Non-Material Amendment under Section 96A

Change in Garage door to plot 5 - following grant of planning permission reference 20/00679/REM (Reserved Matters application for the approval of access, appearance, scale, layout and landscaping for 6no. dwellings on approved application 16/02759/OUT at Field West Of Lea Hall Splitty Lane Catton NE47 9QU)

This application seeks approval of a non-material amendment to the 'principal elevation' of House Type 2 on Plot 5 of the approved development for 6 new homes at Catton.

PRINCIPAL ELEVATION

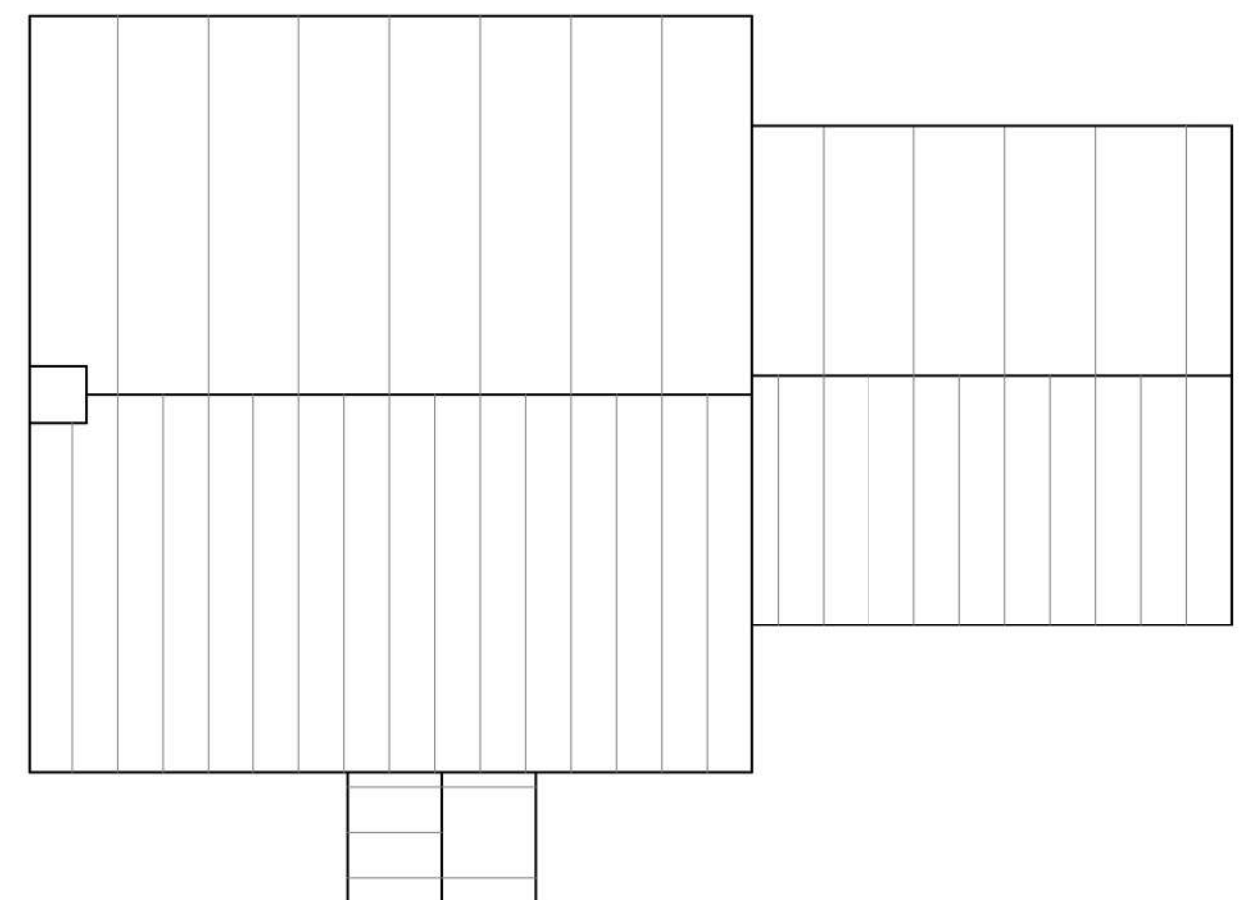
The amendment seeks to replace two garage doors with a single door, omitting the central stone pillar. The applicant seeks the amendment to facilitate easier parking of vehicles avoiding the need to manoeuvre around a central pillar.
